**Response to Planning application from Hertfordshire County Council (T and CP GDP Order 2015)**

District ref: 6/2023/0508/FULL  
HCC ref: WH/16357/2023  
HCC received: 8 June 2023  
Area manager: Manjinder Sehmi  
Case officer: Graham Burrell

Hatfield Manor Care Home Hatfield Avenue Hatfield AL10 9UA

Change of use from 5 staff and 1 visitor bedrooms (class C2) to 6 resident bedrooms (class C2), reconfiguration of site yout/landscaping to provide 7 additional parking spaces and relocation of cycle storage

Drawing Title
Proposed Cycle Store Details No.2

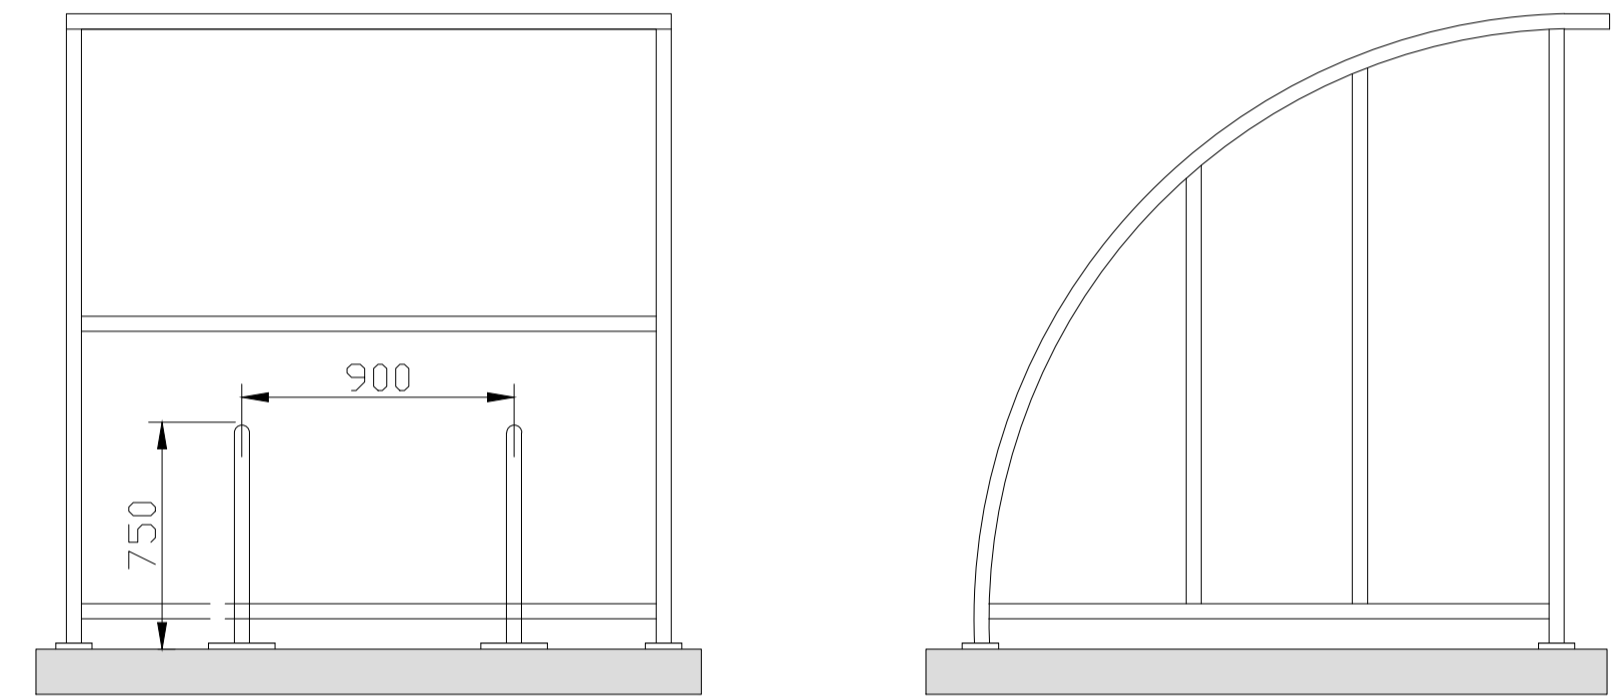
Drawing no. (90-) 4, revision A provides details of a proposed cycle store on the site. Table 11-2 of the Government's Local Transport Note 1/20 (July 2020) provides recommended and minimum dimensions for banks of Sheffield stands. This recommends a distance of 1.2 metres between Sheffield stands and a minimum distance of 1.0 metres. Drawing no. (90-) 4, revision A, shows a proposed distance of 0.9 metres between the two Sheffield stands. This should be revised. The intent is to ensure that there are adequate dimensions for easy parking and removal of cycles from the storage area, thus encouraging cycle trips through ease of use.
